Memorandum

To: Timothy Lock, RA
From: Steve Groves
Date: May 19, 2014
Subject: Cumberland Ave Peer Review

In response to Woodard & Curran stormwater review comment dated 5-5-14 of the Preliminary Level III Site Plan Application for the proposed multi-family building located at 97 Cumberland Ave, we offer the following responses in the order in which they were received.

SITE PLAN OF:
97 CUMBERLAND AVENUE
BY CUMBERLAND AVENUE
PORTLAND, MAINE

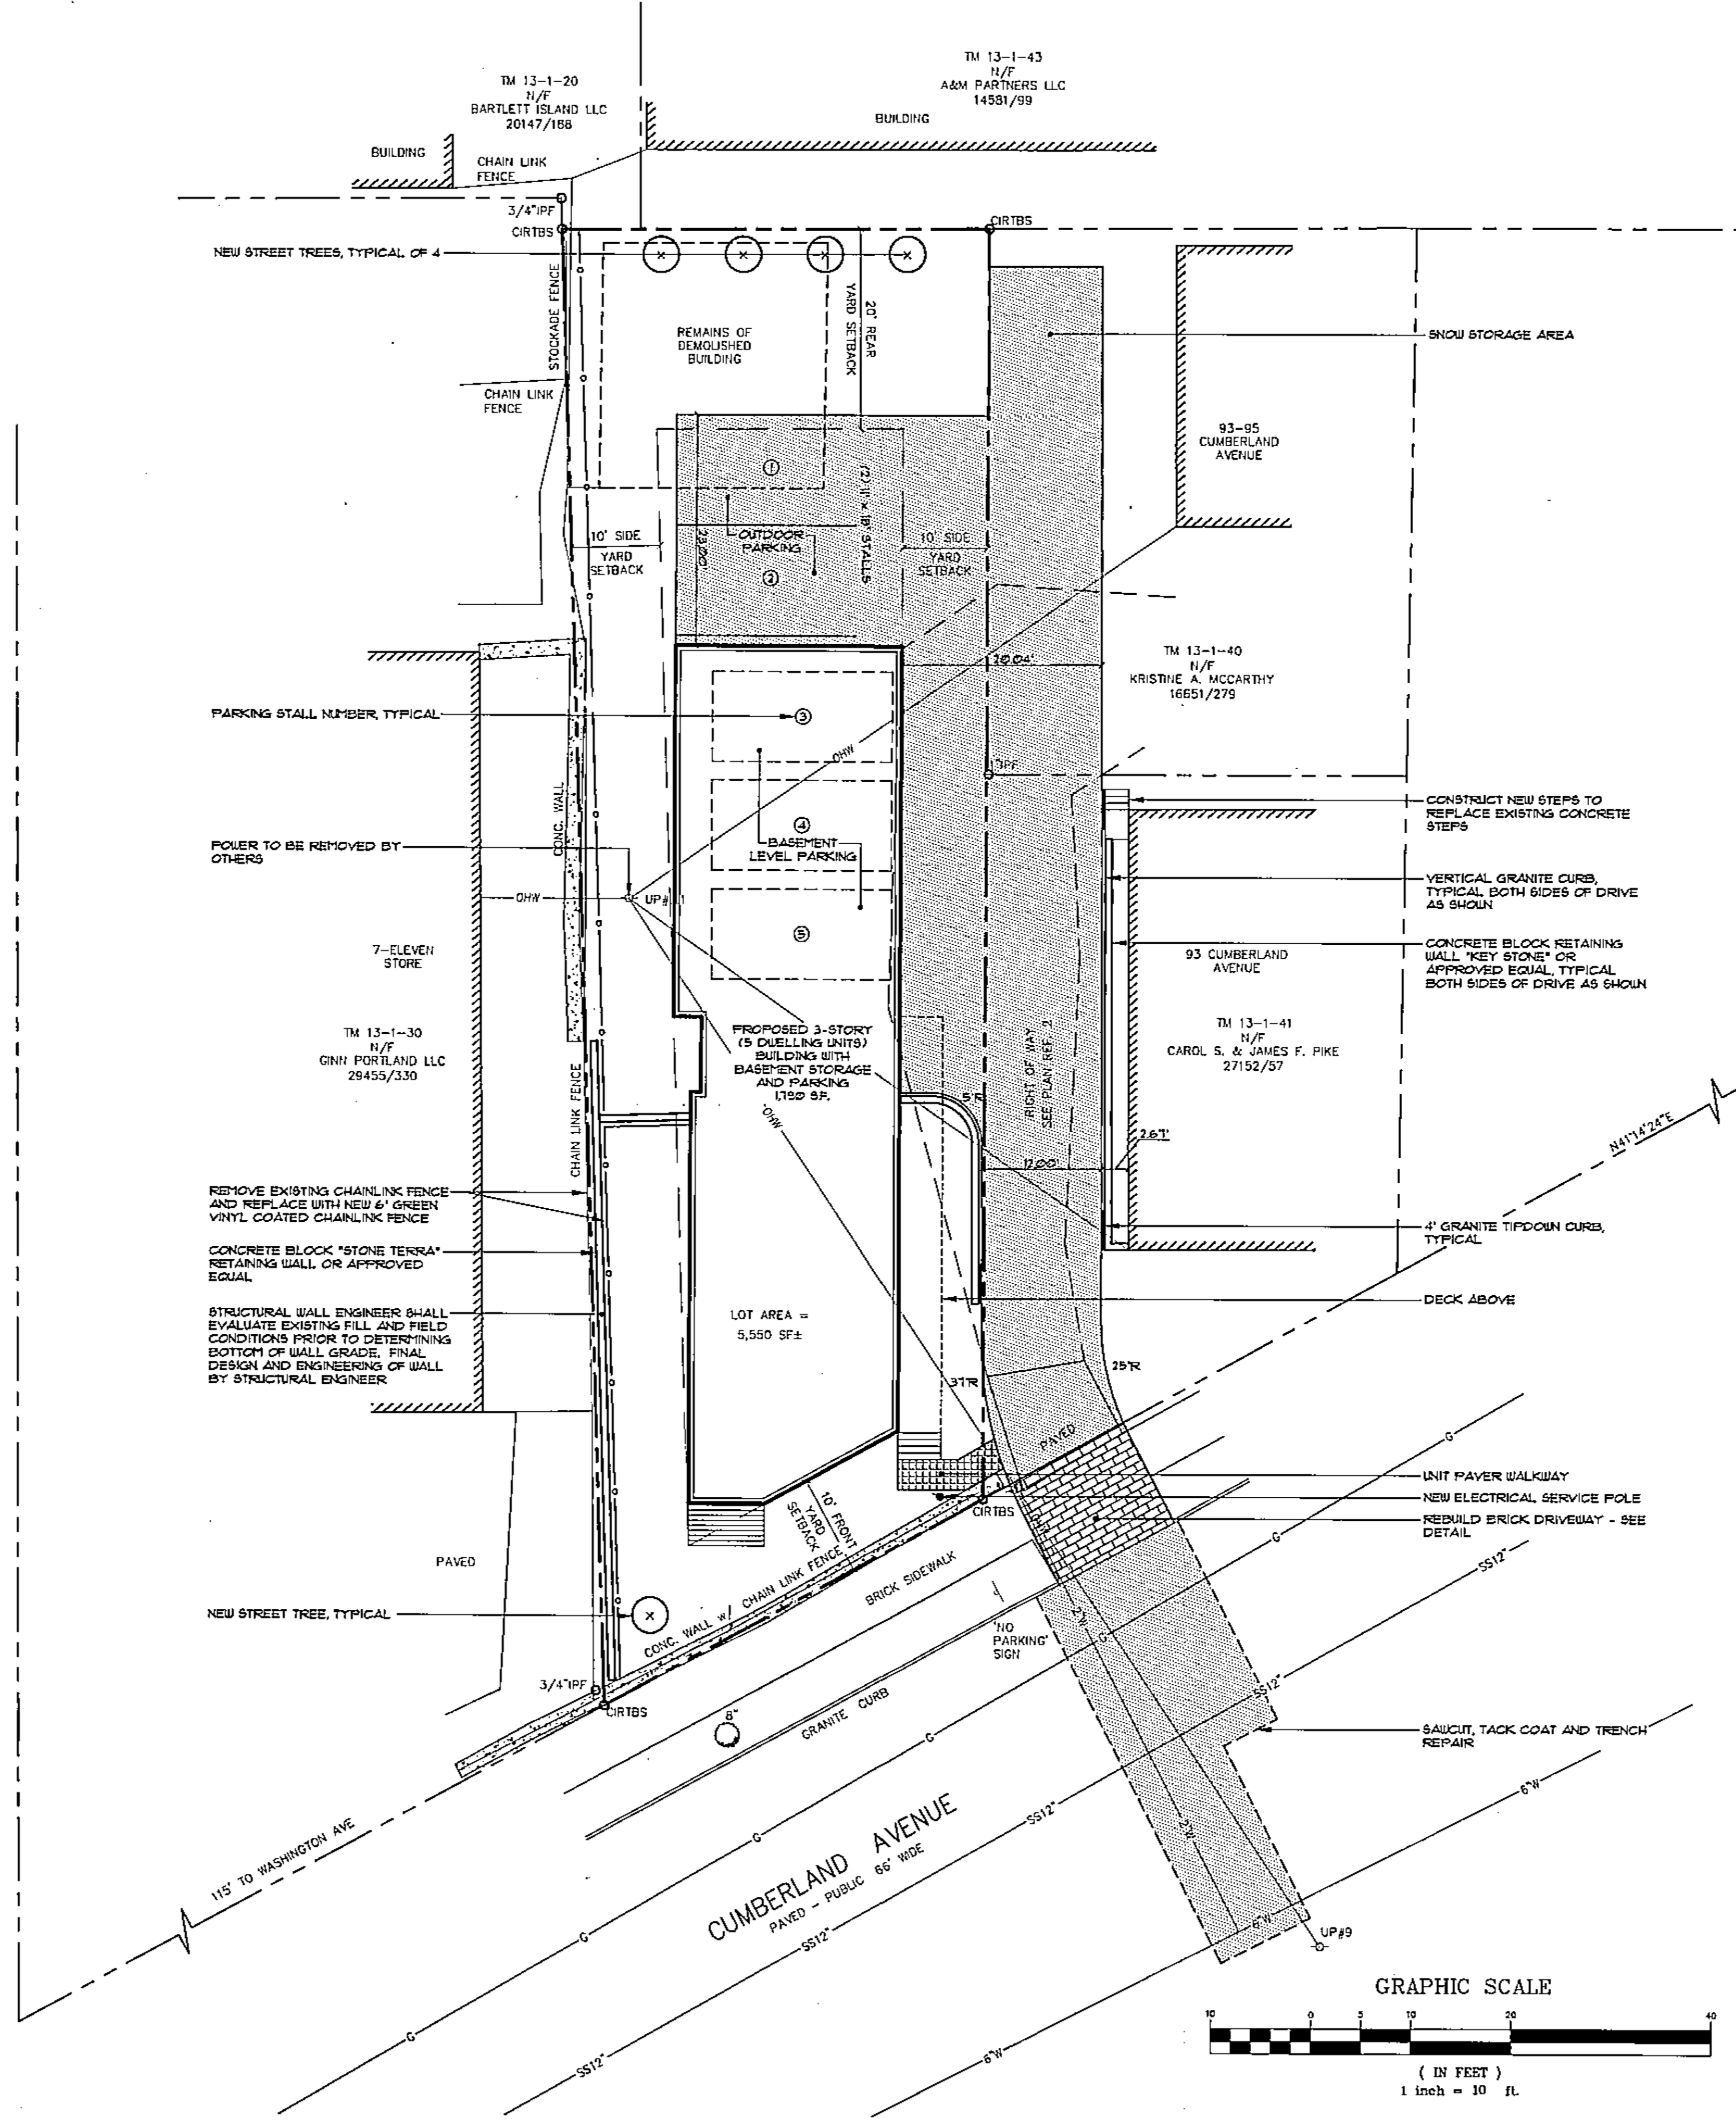
- 8) The existing site includes a utility pole that provides overhead service (presumably both electrical and telecommunications) to buildings on three adjacent properties. The plan calls for eliminating this pole and the associated existing overhead services; however, it does not address how new services will be provided to all adjacent properties, specifically the 7-Eleven store.

The owner is working with CMP and 7-Eleven for a new service connection

INFILTRATION POND
NOT TO SCALE

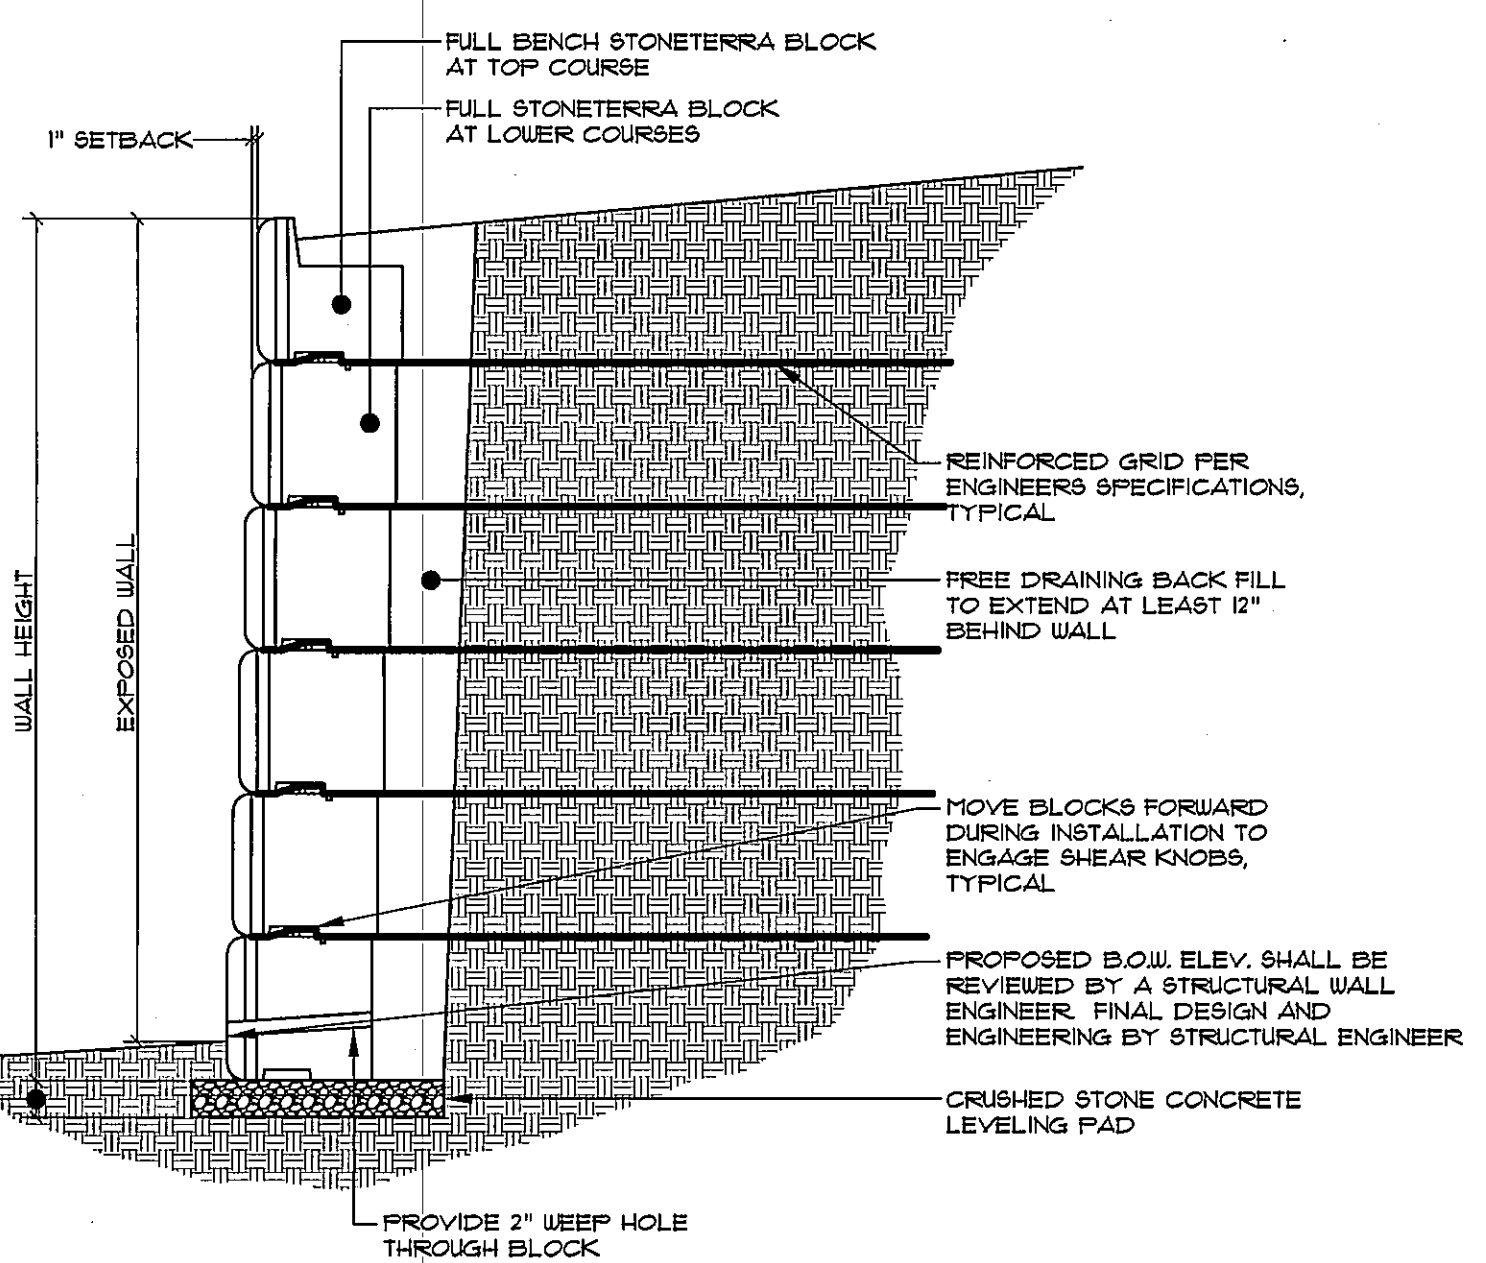
- 5) The proposed infiltration basin is located partially within the footprint of the former house structure. Has the building foundation been fully demolished and removed. What are the drainage characteristics of the fill materials that have or will be utilized in this area? Has the Applicant performed a test pit or boring to evaluate the soil characteristics or infiltration capacity? How deep is bedrock at this location?

- 6) The Applicant proposes a rip-rap spillway to manage overflow from the proposed infiltration basin. Overflow from this spillway will drain west, below a stockade fence, across a fenced dumpster area on the 7-Eleven property, and across the 7-Eleven parking lot to the Washington Avenue drainage collection system. The applicant notes that this route is similar to the pre-development drainage pattern (existing condition); however, a review of the HydroCAD model indicates that more area will be directed to this location in the post-development condition, and although the infiltration basin will provide minor detention, the model predicts an increase in runoff rate at this location (from the spillway) in the post- development 10- and 25-year storm events. The drainage design should be revisited to eliminate directing overflow onto the neighboring property, unless the Applicant obtains drainage easements from N/F Ginn Portland LLC and modifies the adjacent fence and dumpster/parking area to accommodate drainage from the site. The Applicant should propose an alternative means of managing overflows from the infiltration basin.

The Cumberland County Soil Map indicates Hinckley gravelly sandy loam having Hydrologic Group A. At the time of this report the infiltration basin was cover with ice. We now can dig a test pit to confirm the underlying soils.

The increase in flow is 0.01cfs which is insignificant and within the accuracy limitations of the model. There is no public storm drain system available adjacent to this site that we can connect into. There are no viable options except overland flow. And furthermore historically this property was developed prior to 7-Eleven, and it is our belief that the developer of 7-Eleven took into account the offsite drainage at that time. It would appear that the old house roof drained directly onto the neighboring property.
